APPLICATION NUMBER 3/2011/0443
Old Clay Lane, Thornley-with-Wheatley
GRID REFERENCE SD 597 398

A planning application has been submitted by Mrs Julia Pye on behalf of Mr Morris Airey for the erection of a multi-purpose agricultural building. A site visit was made whilst the applicant and his agent were present. The information provided at this meeting, together with the written submissions forms the basis of this appraisal.

It is proposed to erect a building as shown on drawing number JP/MA/33/141. The building would be part open fronted, with 5 bays being used for livestock housing and the remaining two bays for storage.

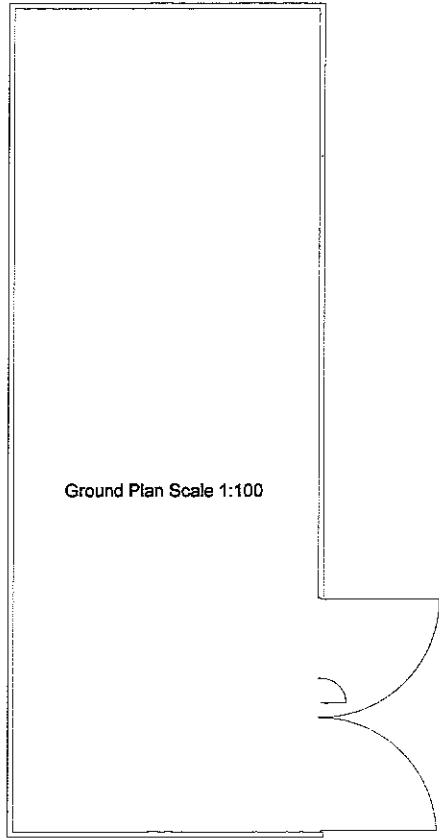
The building is of a typical agricultural type construction. It is part open fronted and has timber spaced boarding to the sides, providing good ventilation for the livestock. The building would benefit from overhanging eaves although this is not essential. No doubt you will have your own opinion regarding the colour of any sheeting used.

I am of the opinion that the floor area of the proposed building and height are acceptable.
